Response to Submissions re 85 Harrington Street Development Application						
Date of Issue: Wednesday, 18 October 2017						
Source	Item	Issue/Object	Description	ADG Objective	Drawing Number(s)	FJMT Responses
DoPE Letter Attachment A	1.1	Visual Privacy	Balconies serving units on Northern side of Building 2 have been reorientated towards Rendezvous Hotel. Provide a specific plan illustrating the varying setbacks between the two buildings, location of facing windows and balconies and proposed design measures to mitigate potential privacy impacts.	N/A	002 - 003	Solid, operable shutters, or horizontal metallic blinds that are controlled by the occupants of the unit are employed to provide privacy towards the subject site. The windows of question within the rendezvous hotel are fixed, have dark glass and the rooms are itinerantly occupied. Any potential privacy issues have been mitigated through a considered design response. Complies? Yes

85 Harrington Street
The Rocks
GOLDEN AGE & HANNAS THE ROCKS

TITLE
RESPONSE TO DoPE
Responses to Items

1 PLAN 1 BED - Pre-Adapted Layout
1:50

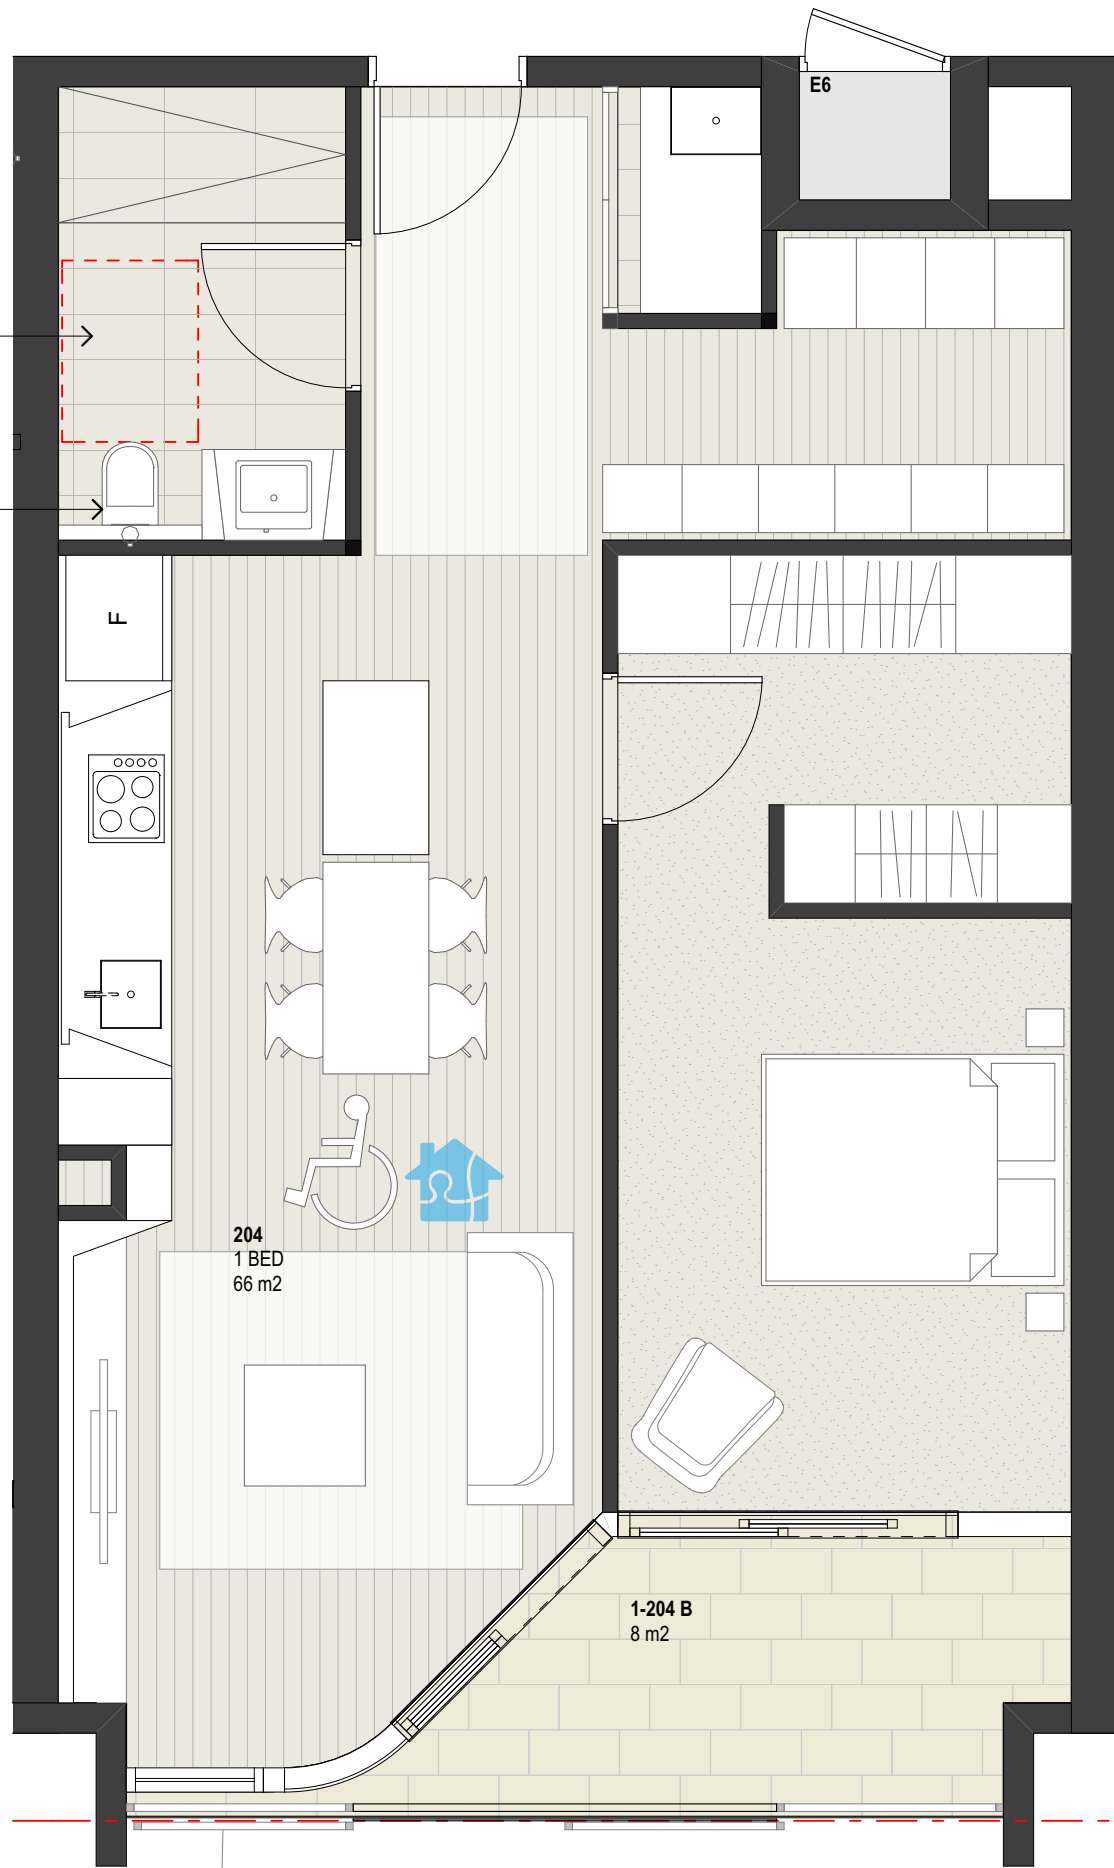
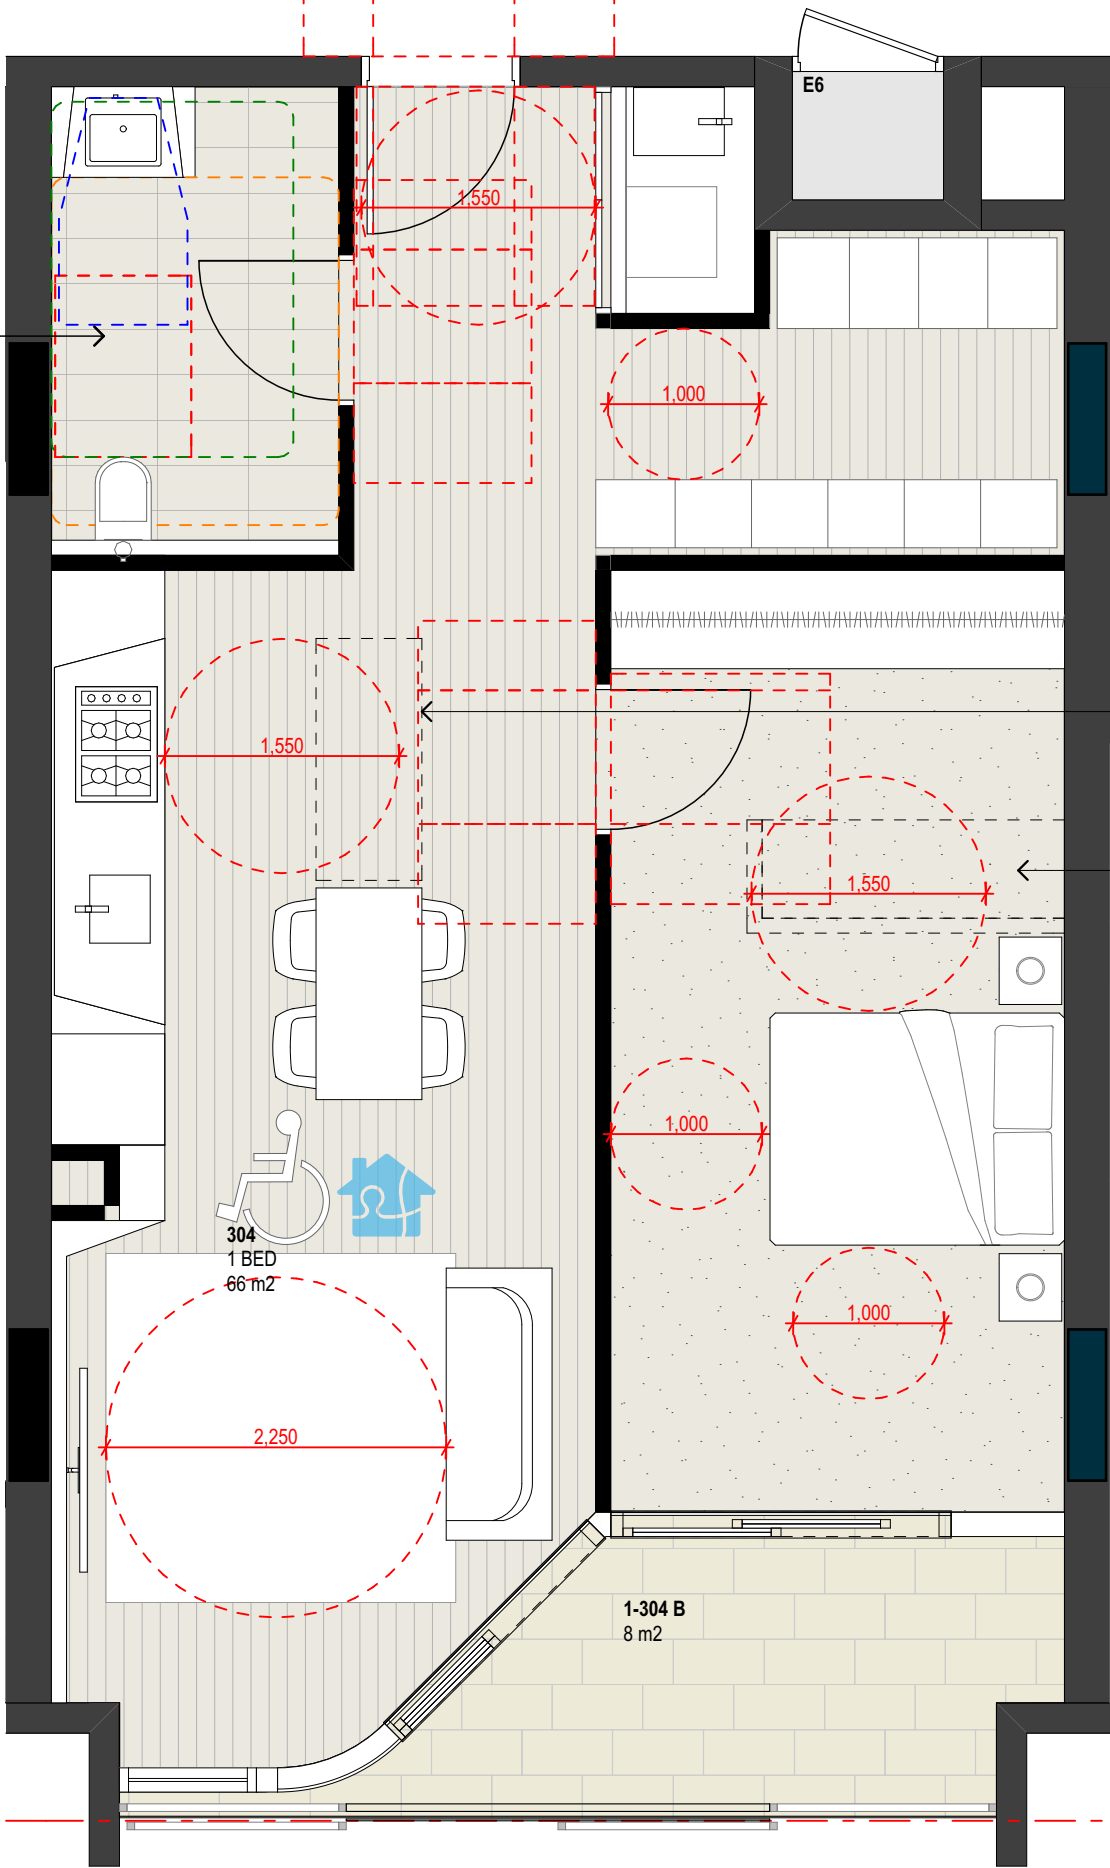
5.10	Additional Information	Adaptable and Liveable Housing Guide Drawings		050 - 055	Additional information provided as requested. Apartments subject to Adaptable and Liveable Housing Guides have been provided and updated where required as part of planning changes. Complies? Yes
City of Sydney Submission Public Submissions	6.1	Bulk and Scale	Concerns regarding increase in height and scale that is exceeding SCRA envelope.		056	Height and bulk supported by Peter Webber. Complies? Yes
